Permit Number: 080400

City of Portland, Maine - Building or Use Permit Application

Proposed Use: Commercial - Amend permit #08-0082 - 2nd floor work move lunch room to rear. Add partition and add a window.	Proposed Project Description: 2nd floor work to move lunchroom to rear - Add partition upstairs and add a window.
---	--

Proposed
Killer
Escape

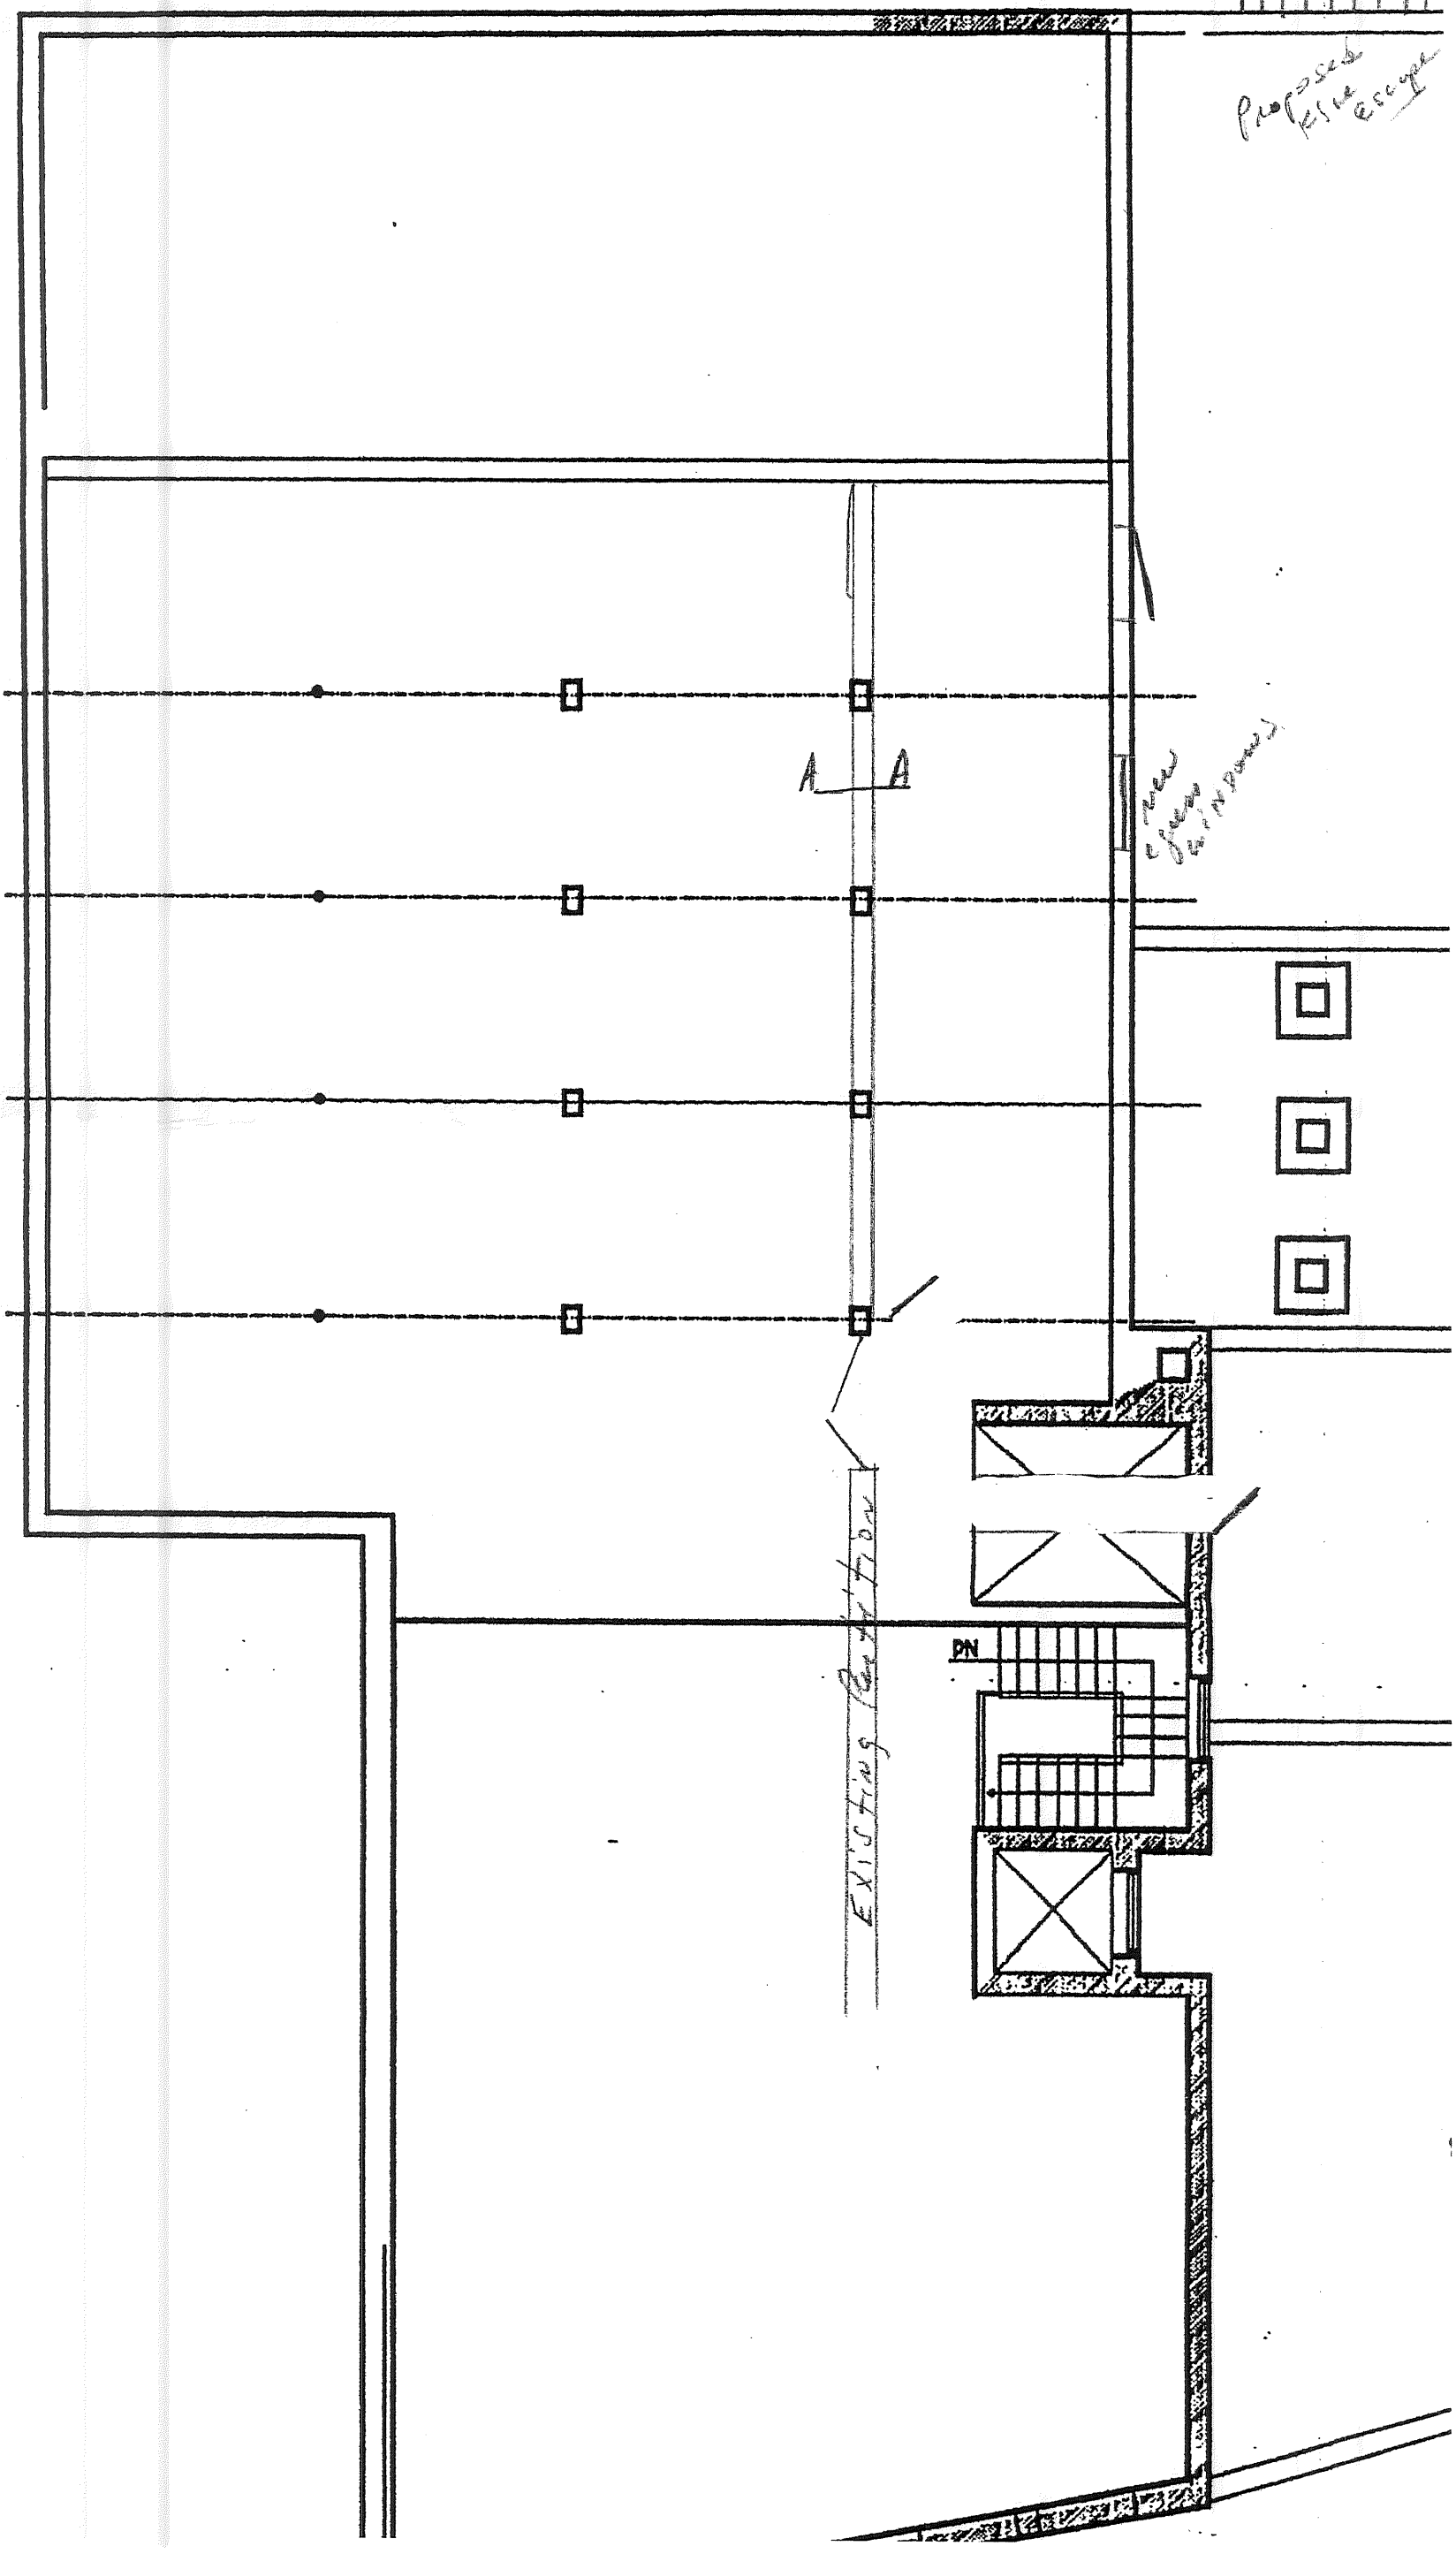
- 1) Review emergency lights and exit sign placements.
2) Details and separate permit required for fire escape.
